Ribble Valley Borough Council

App no: 25.0095

Address: Land at Higher Road Longridge PR3 2YX

The submitted documents and plans including PSA Design Transport Statement and 'Proposed Access and Visibility Drawing H4322-H-01 Rev P1' have been reviewed and the following comments are made.

Annex 3 – Illustrative Access Layouts

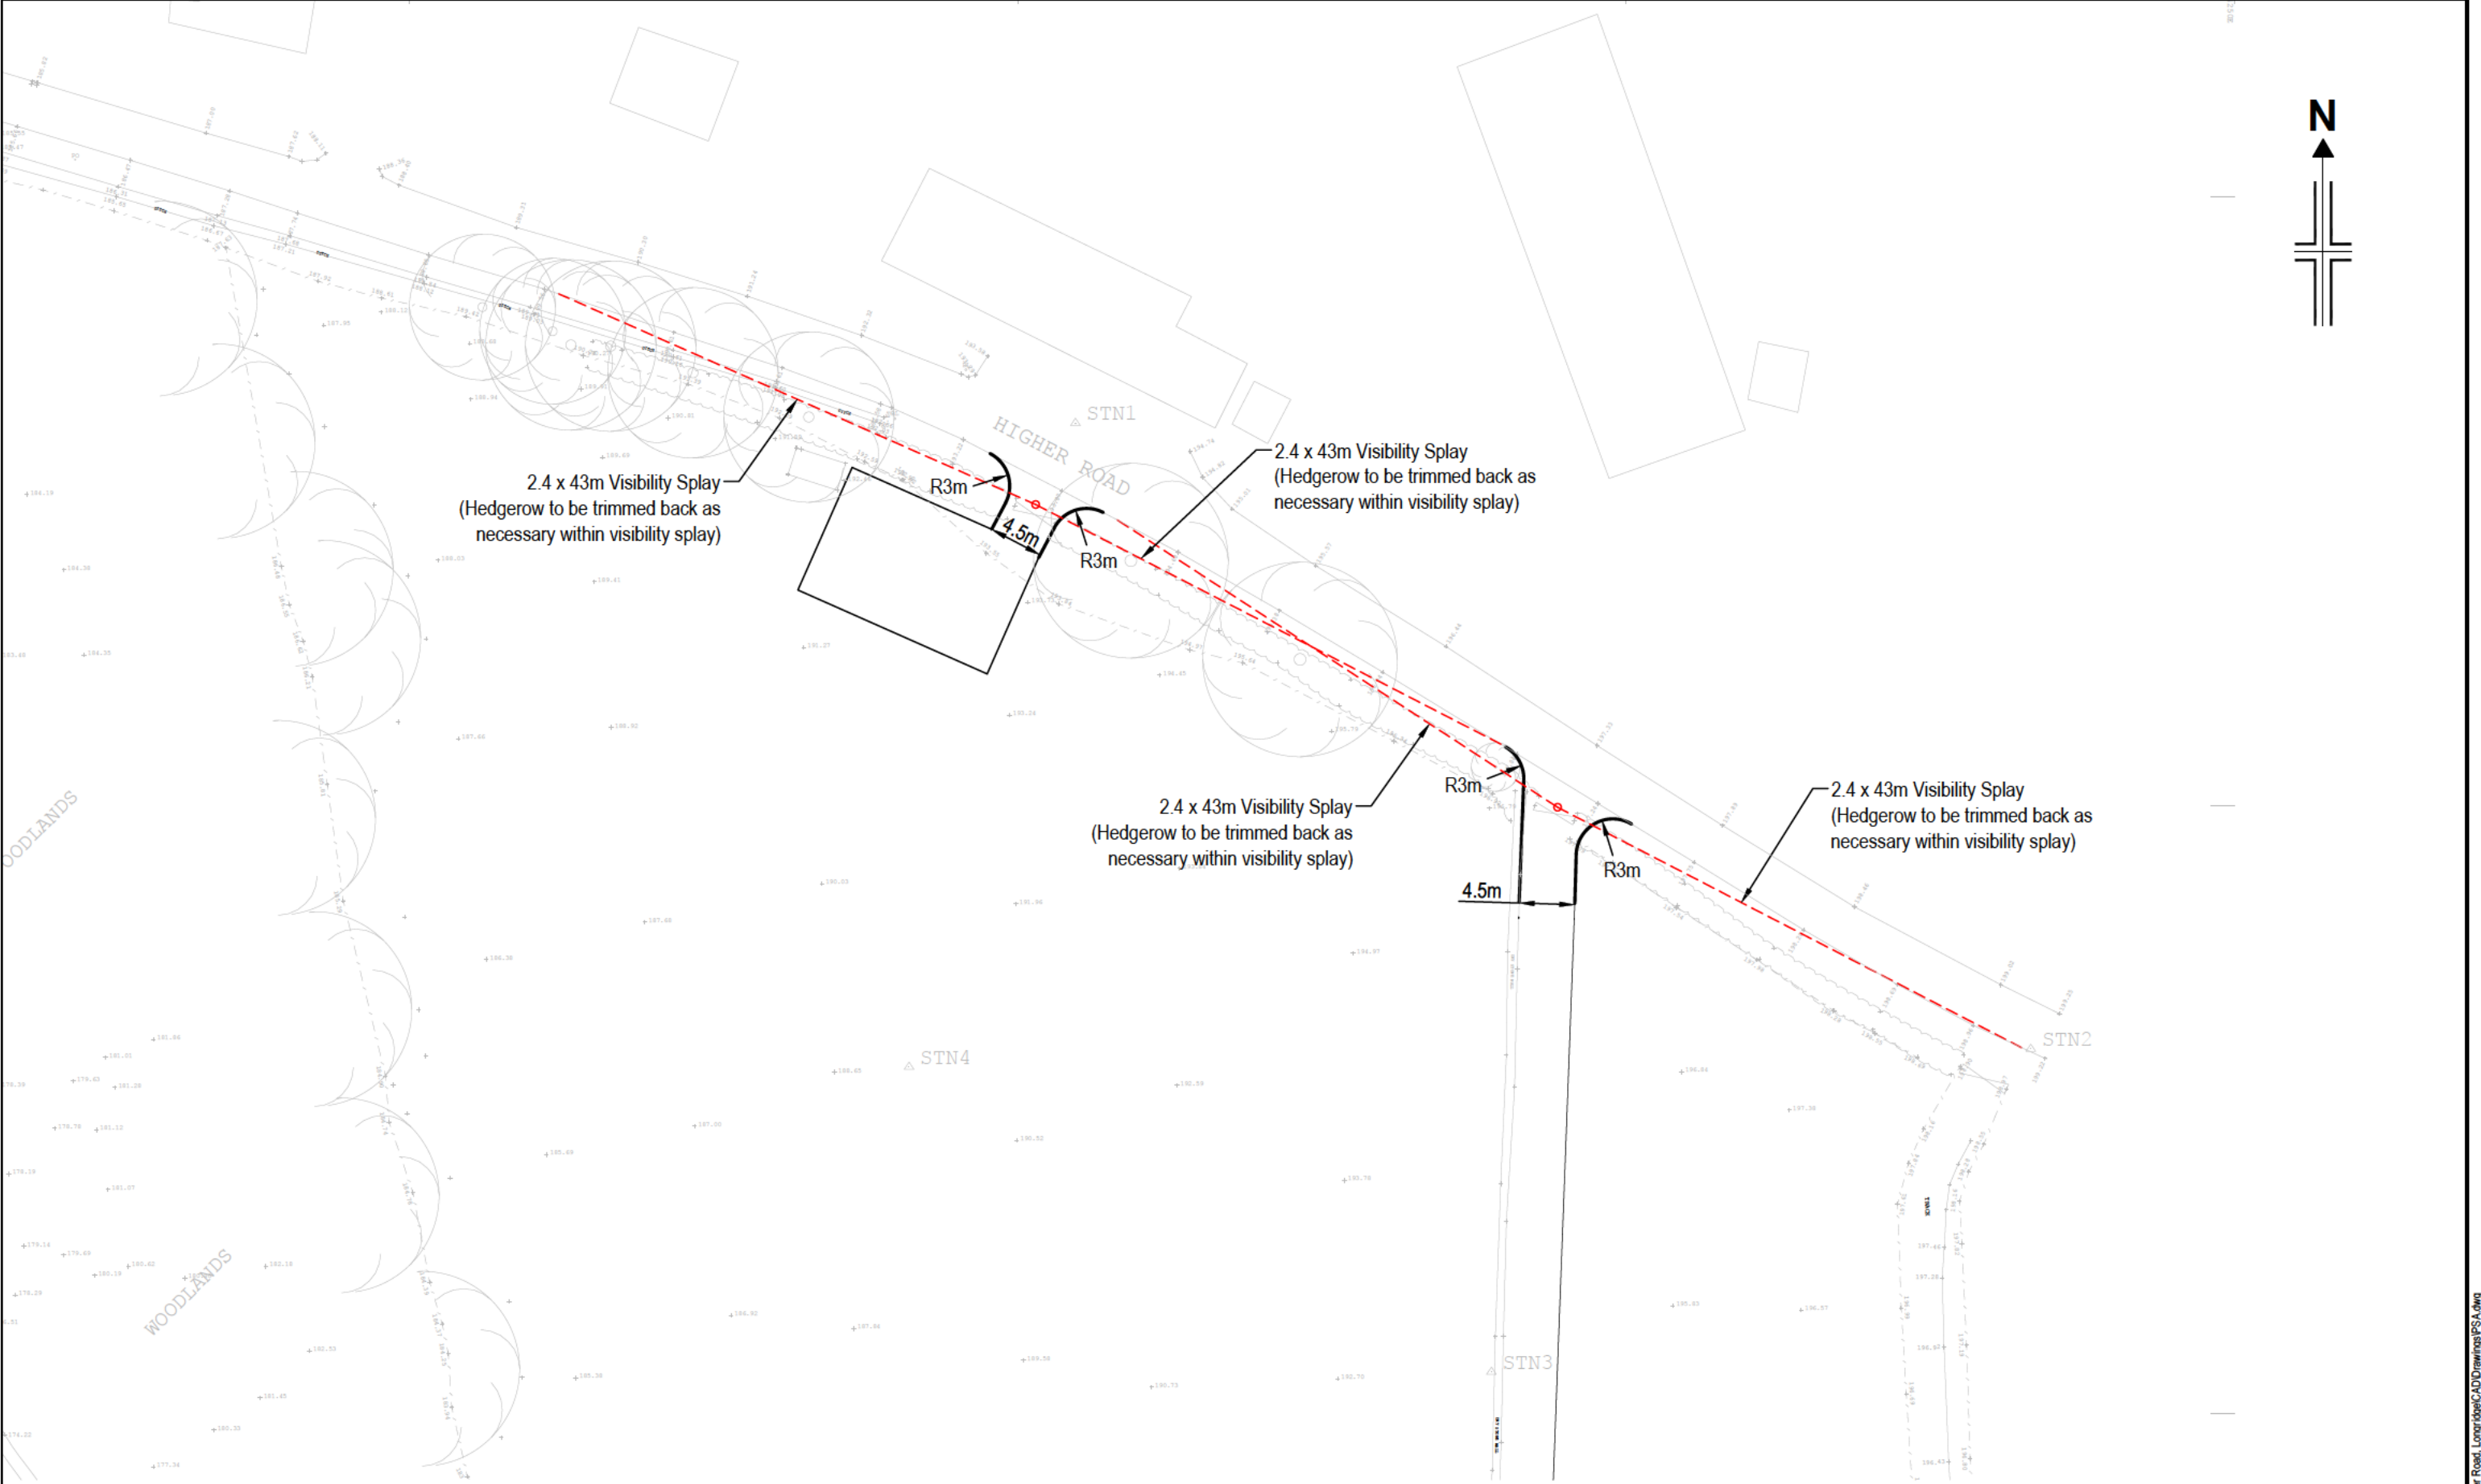
Visibility splays of 2.4m by 43m to both sides of both accesses are shown on 'Proposed Access and Visibility Drawing H4322-H-01 Rev P1' and lie over the highway or land within the applicants control. There is vegetation within the splays which is proposed to be reduced to below 1m high.

These splays are suitable for a speed limit of 30mph which is below the national speed limit on Higher Lane. An application at Blue Bell Farm which lies 1.2km west of the site collected 85%ile vehicle speeds over a 7-day period in November 2022 of 37.8mph EB and 36.1mph WB on Higher Lane.

Due to the lack of other speed data at this site, we would request the speeds at Blue Bell Farm are used to advise the splays here and that they are increased from 43m to 60m to the left side and 56m to the right side of the accesses. This appears achievable within the highway or land within the applicants control without requiring the removal of any trees on the boundary of Higher Lane.

Both the site accesses are proposed at a width of 4.5m which is acceptable. The accesses will need to be either ungated or with the gates set back by at least 5m from the edge of the carriageway. The first 5m of the site accesses will need paving and draining to prevent any loose material or surface water being deposited onto the carriageway. Works within the highway will need to be undertaken under an agreement with Lancashire County Council.

We would request that the visibility splays are increased as detailed above, subject to this we would raise no objection regarding the proposed development and are of the opinion that the proposed development will not have a significant impact on highway safety, capacity or amenity in the immediate vicinity of the site.
